June 25, 2012

**Re: A Class Jumbo Storage, 5132 2nd St NW, Traffic Circulation Layout
Architect's Stamp undated (F15-D052A)**

Based upon the information provided in your submittal received 06-14-12, the above referenced plan cannot be approved for Building Permit until the following comments are addressed:

A1.1

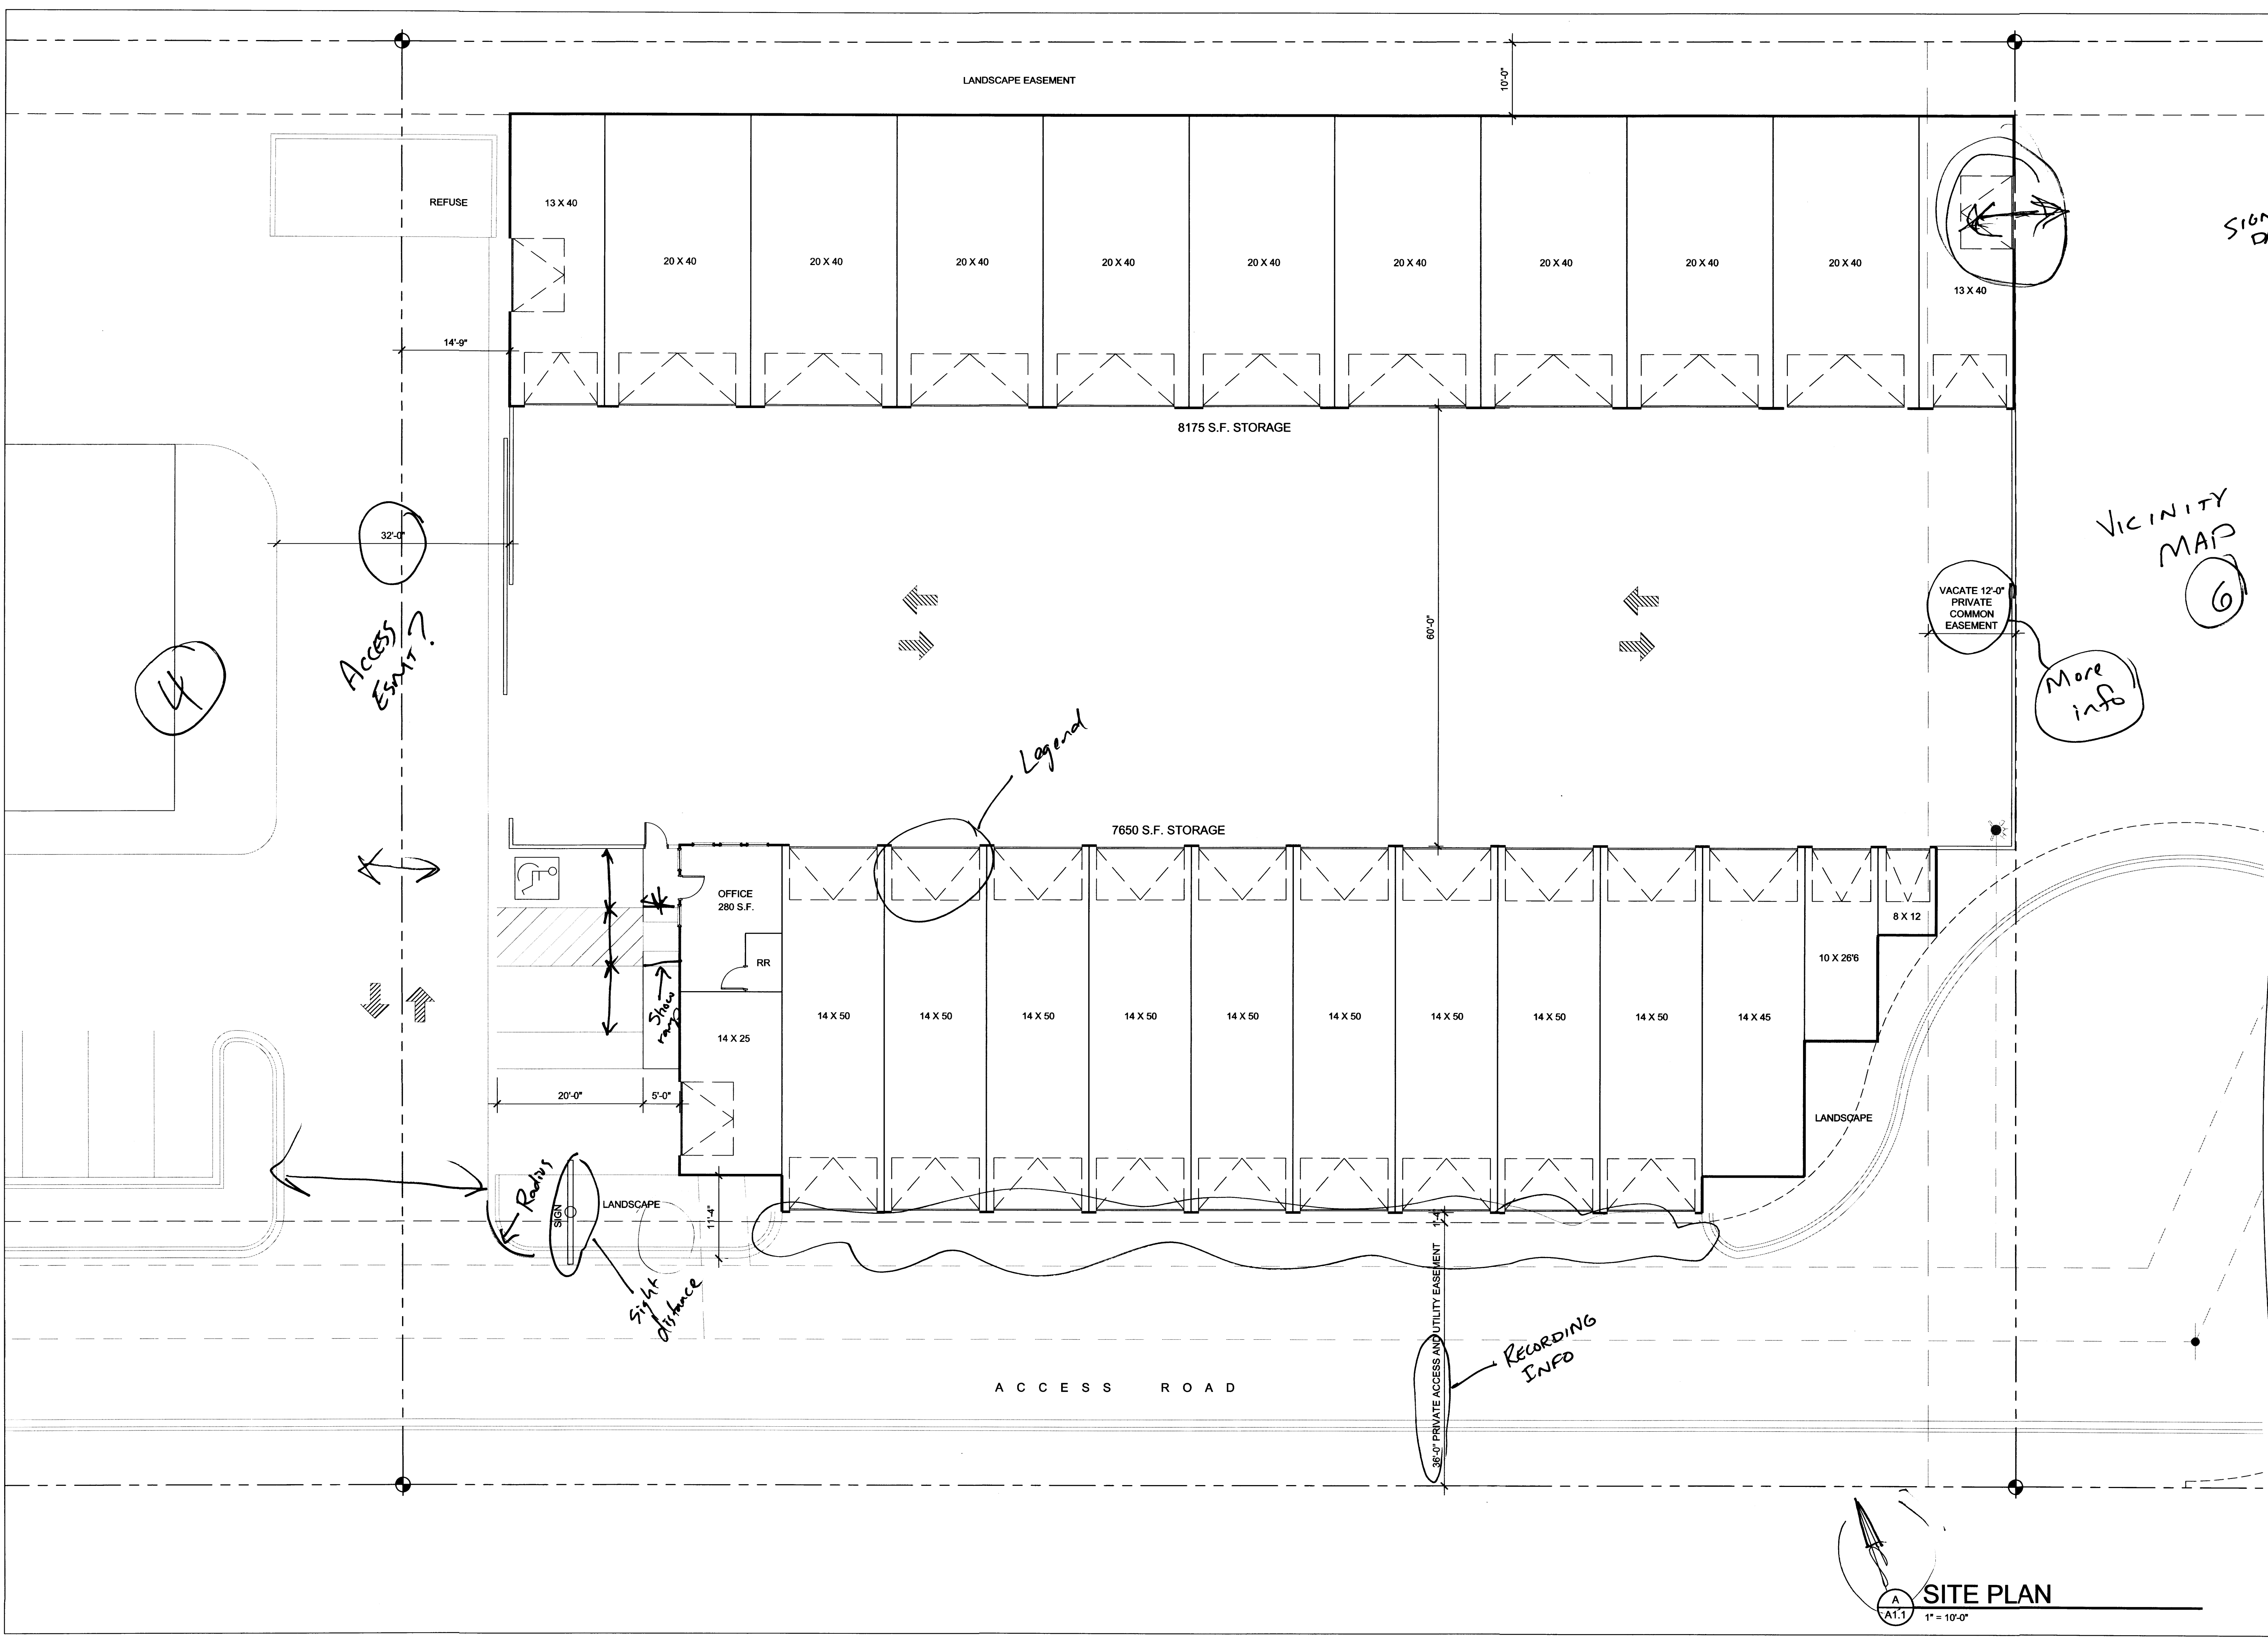
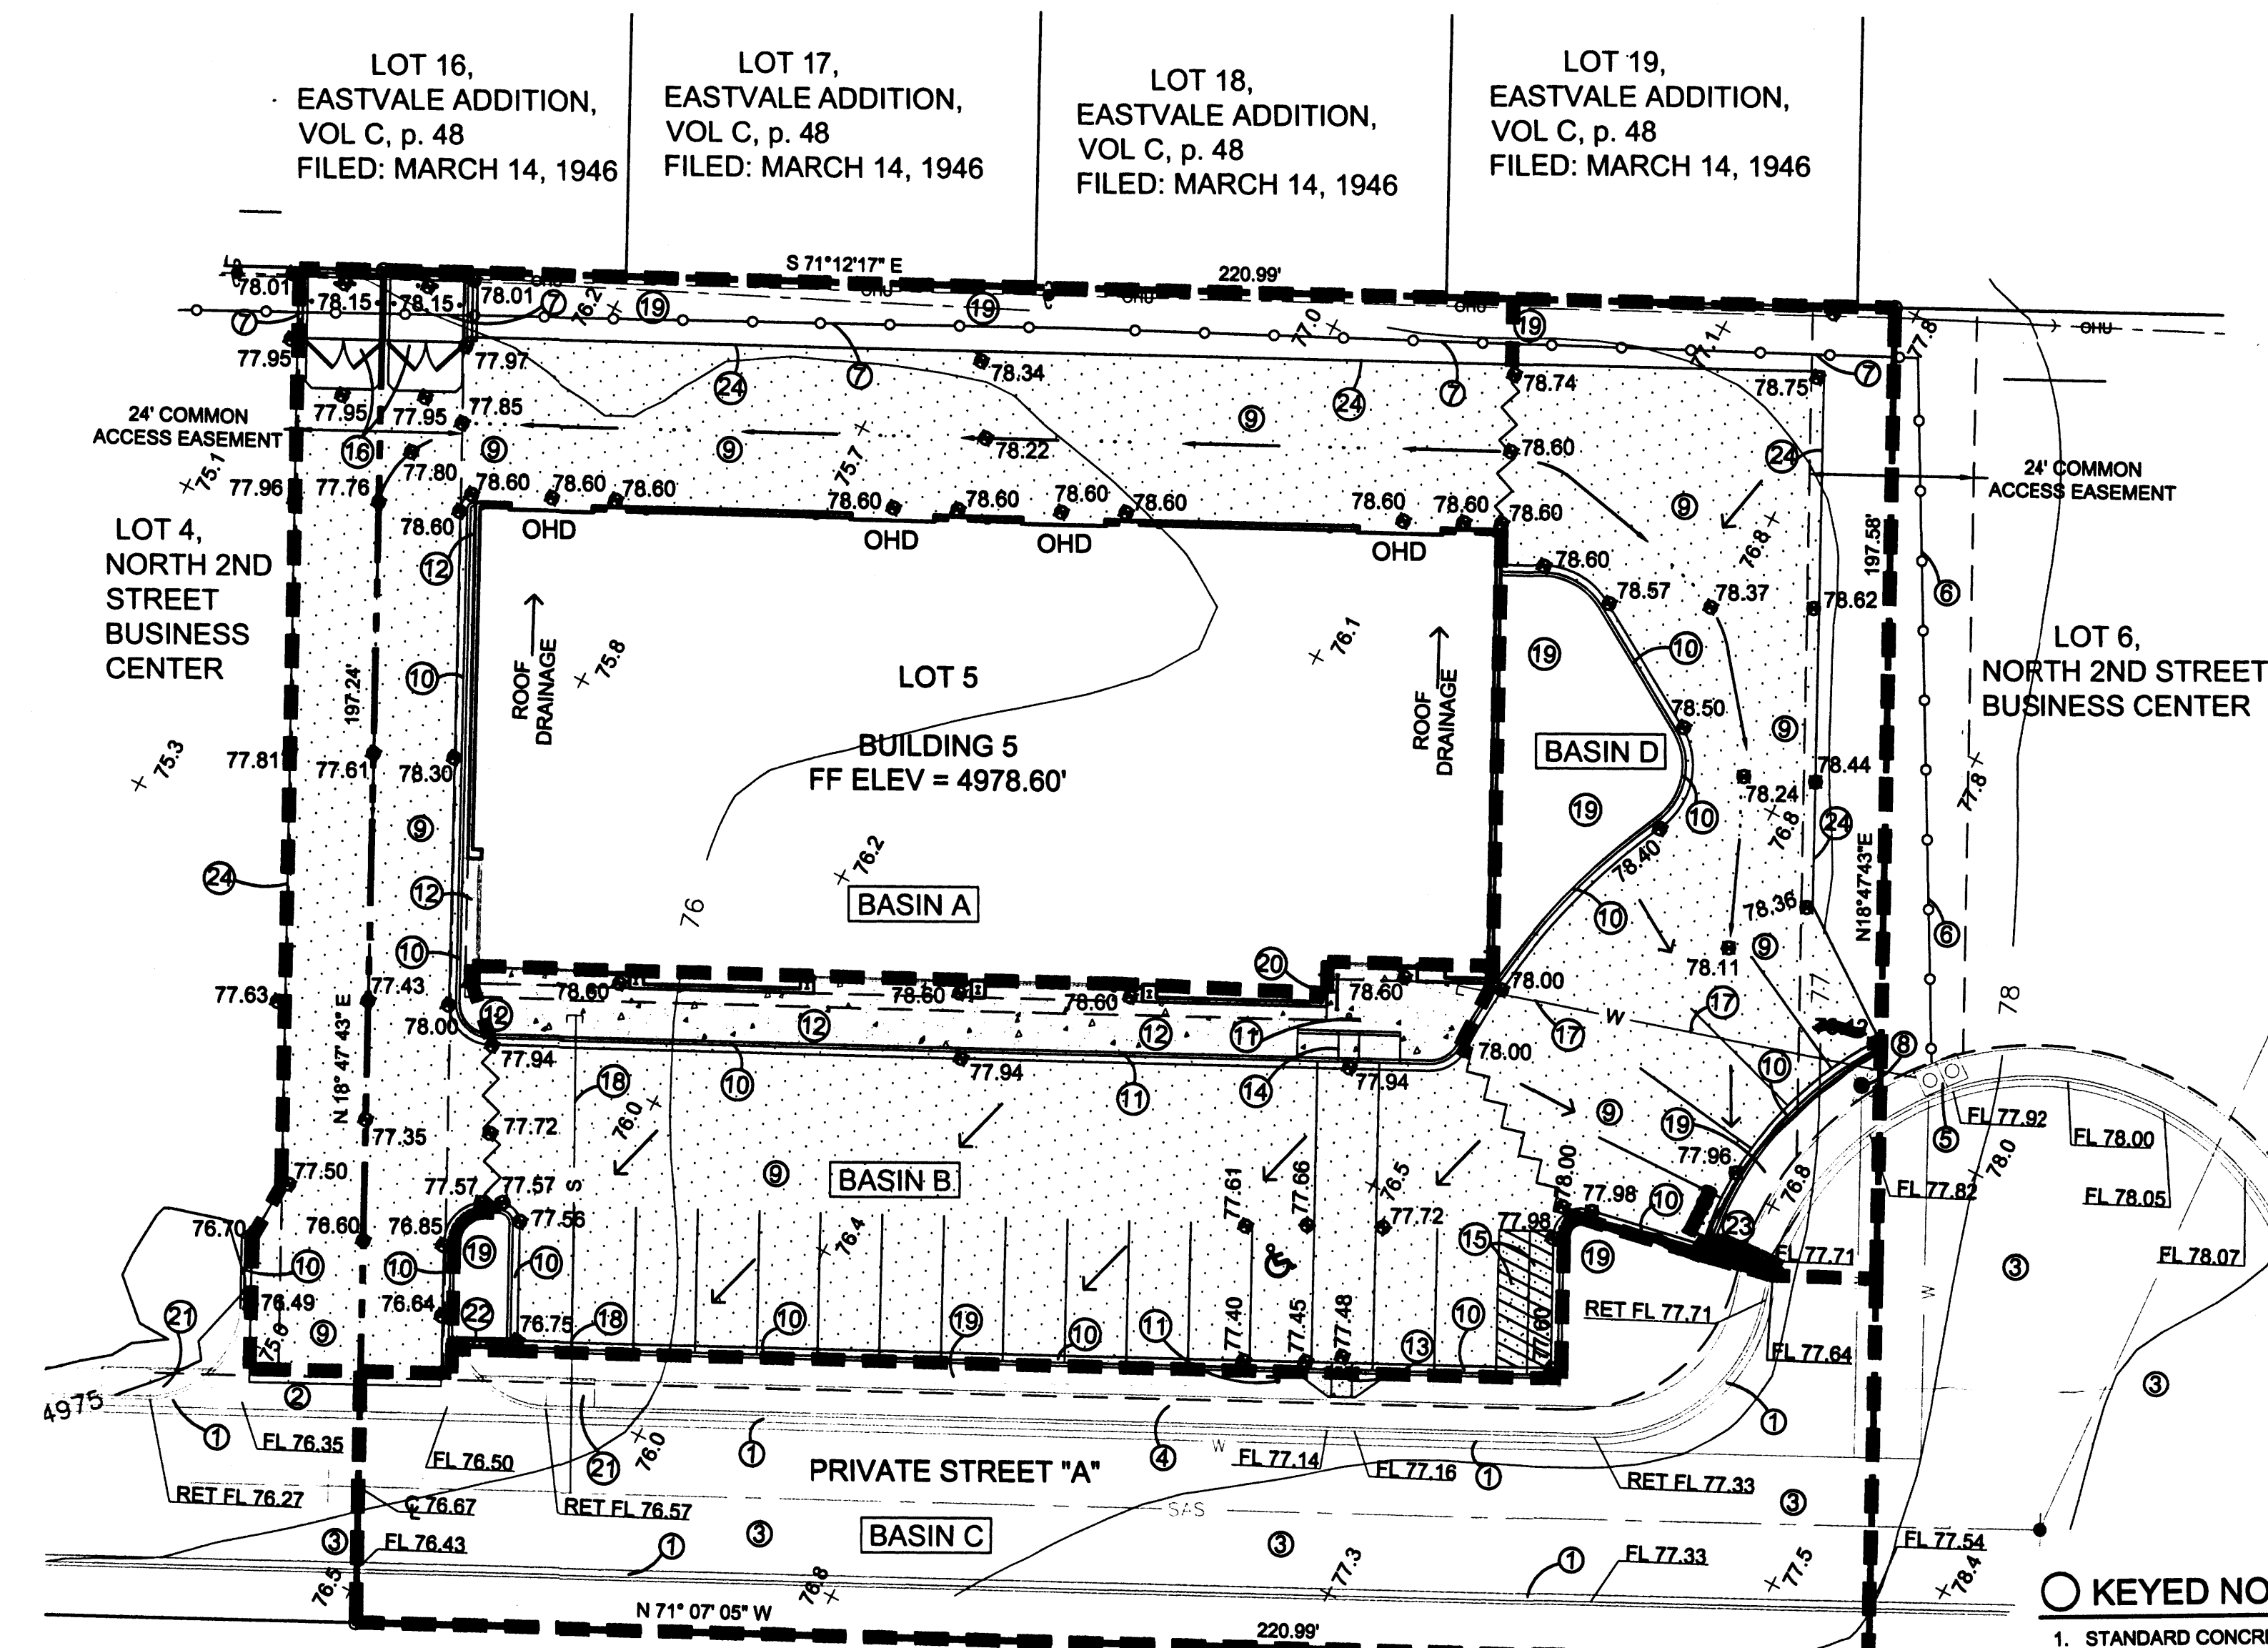
1. List radii for all curves shown; for passenger vehicles, the minimum end island radius is 15 feet.
2. Please list the width and length for all parking spaces.

3. Show all ramps and provide details.
4. Please show the location of the nearest driveway on the adjacent lot.
5. List the number of parking spaces required by the zoning code as well as the proposed number of parking spaces.

6. Please show a vicinity map.
7. The handicapped spaces must include an 8-foot wide van access aisle; all other aisles should be 5 feet in width.
8. Define width of the existing sidewalk.

9. Show all existing sidewalk and wheelchair ramps. Provide geometric information.
10. The traffic circulation layout must be stamped, signed, and dated by an engineer or architect licensed in the state of New Mexico.

11. List the width of the existing drivepad.
12. Please include two copies of the traffic circulation layout at the next submittal.
13. All easements must be clearly defined. Provide the recording information.

14. How will the existing hydrant adjacent to lot 6 be protected?
15. An easement is shown adjacent to lot 6. Please define the purpose and extents of the easement. The easement must be vacated prior to permitting a structure to be built over it.

16. How will vehicles accessing the storage units adjacent to lots 4 and 6 maneuver? Access is shown from these units to the adjacent lots; is there an access easement?

17. Access to the southern storage units from the private roadway is not permitted, as the curb cut would exceed City of Albuquerque standards for width and would interfere with pedestrian movement. Please revise.
18. The proposed sign may interfere with the sight distance of the driveway. Please provide a sight distance exhibit (see the *Development Process Manual*, Chapter 23, Section 6, Part B.12).
